Our Ref: AWE200083-L01: BCP/bcp
Contact: Dr Brett C. Phillips

22nd February 2021

RESPONSES TO FLOODING SUBMISSIONS, ASPECT INDUSTRIAL ESTATE, KEMPS CREEK, NSW

Figure 42 PMF Level Differences - (Stage 1 Conditions – Benchmark Conditions)

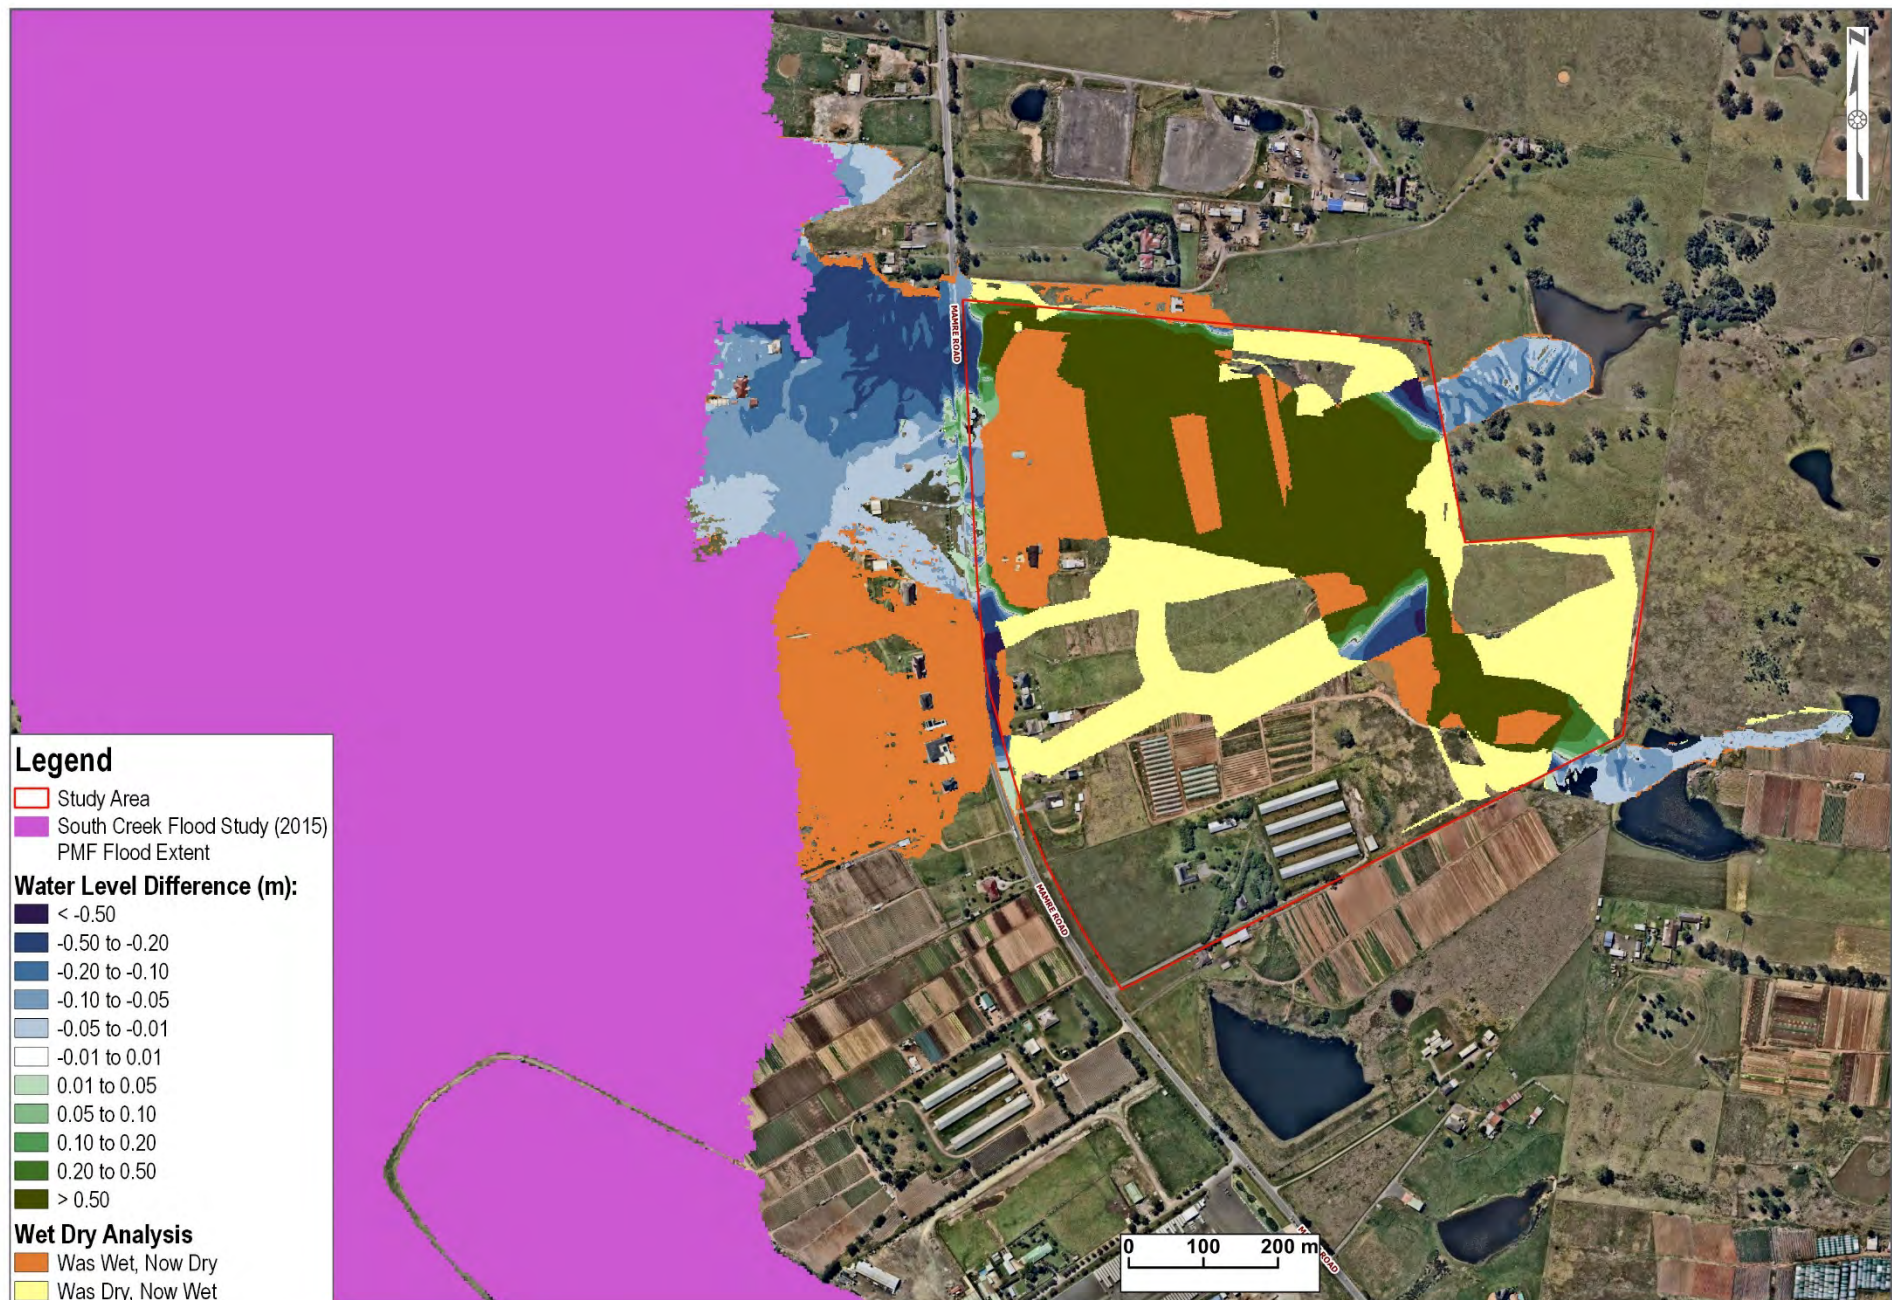
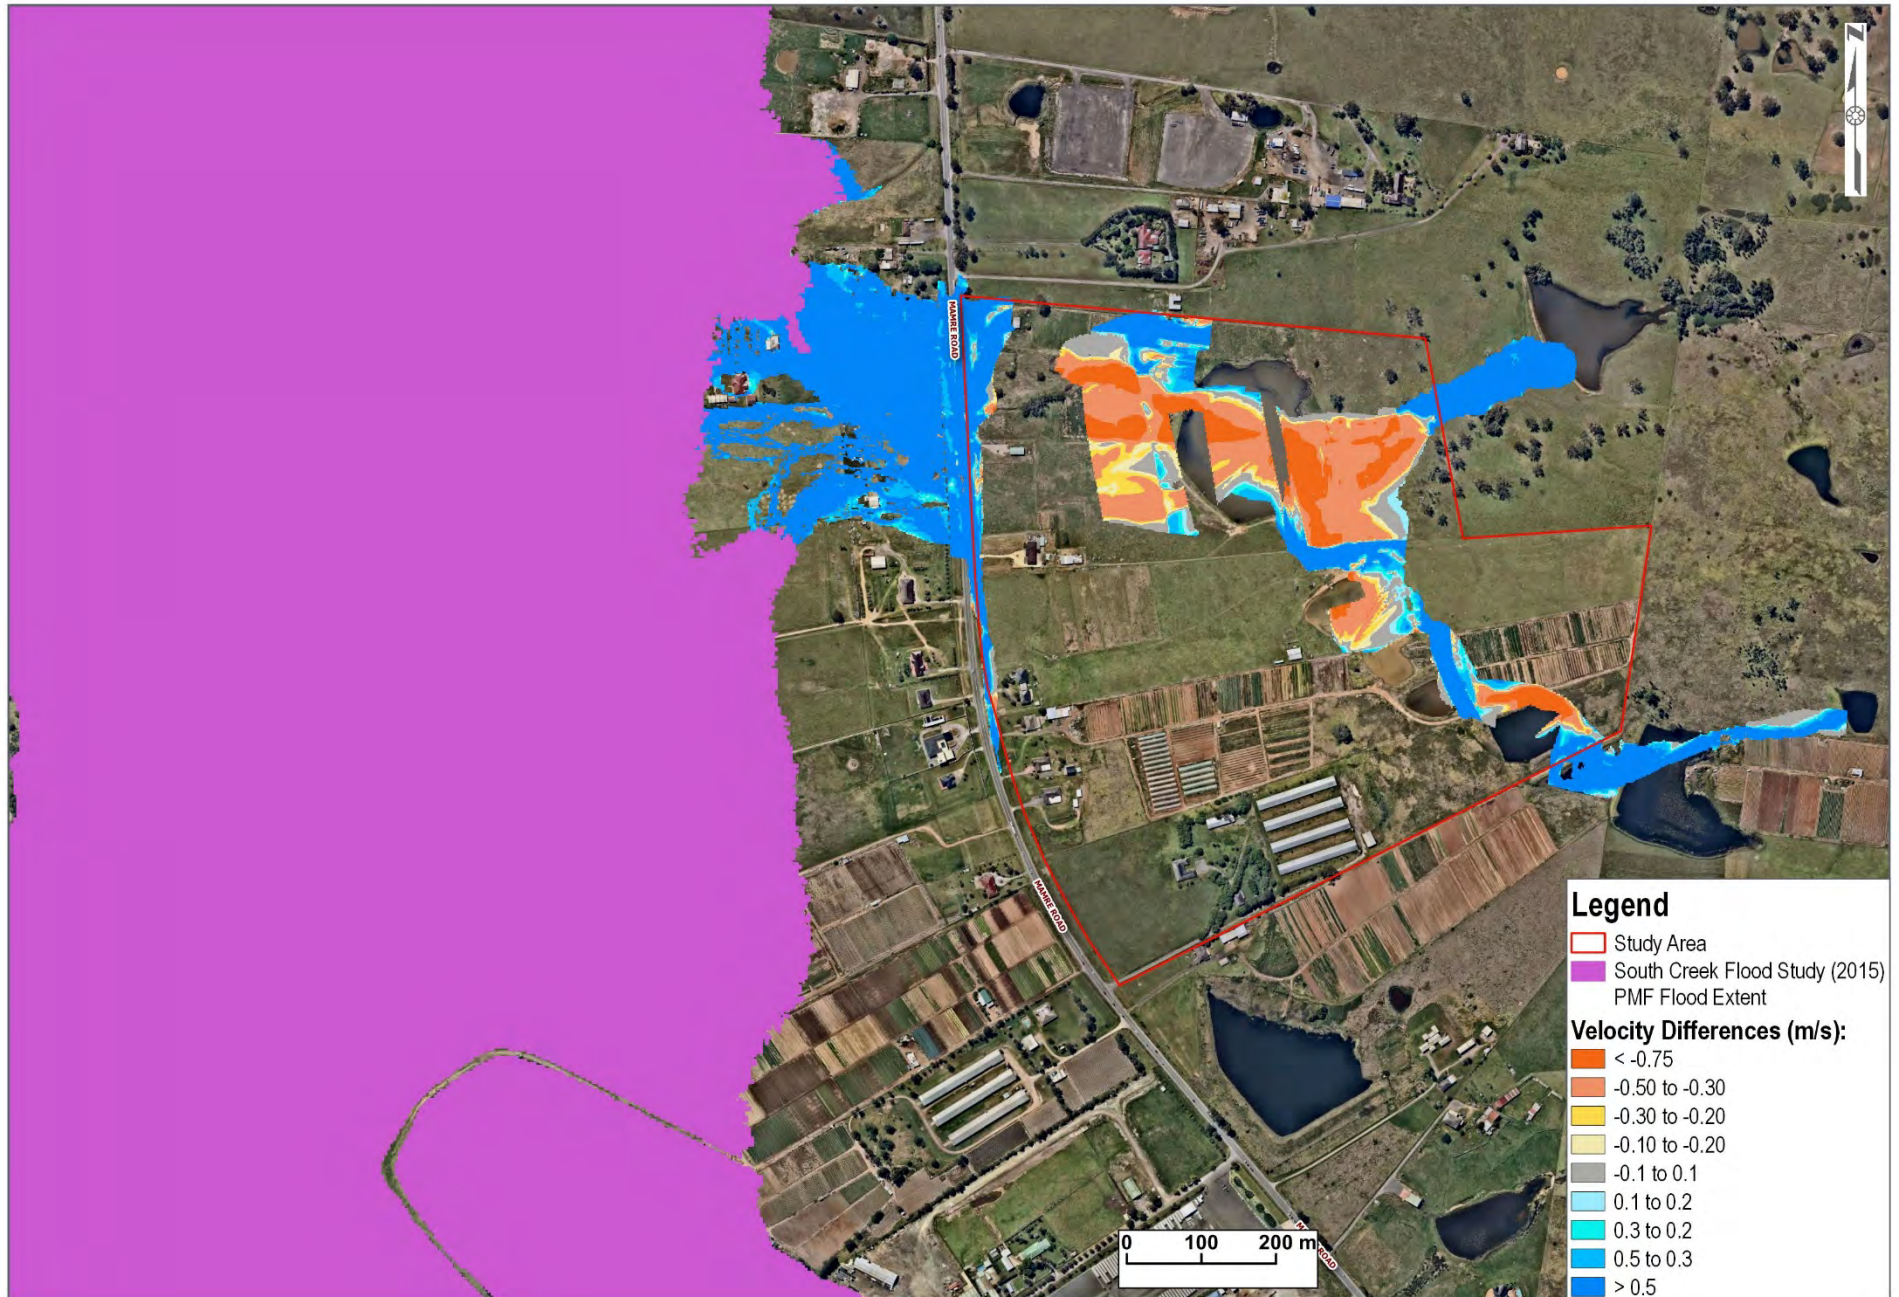
- *The developed scenario maps present local overland flow for Stage 1 which comprises of two industrial lots on the northern part of the site. However, from a flow management perspective, an overland flow study should consider the ultimate developed scenario of the site instead of considering each progressive development independently.*

- *All maps for developed conditions should properly depict the layout of the development, locations of proposed constructed channels and the location of the proposed detention basin.*

The final masterplan has been assessed and the results of the assessment have been incorporated into an updated version of the FIA report.

The updated Figures have been incorporated into an updated version of the FIA report.
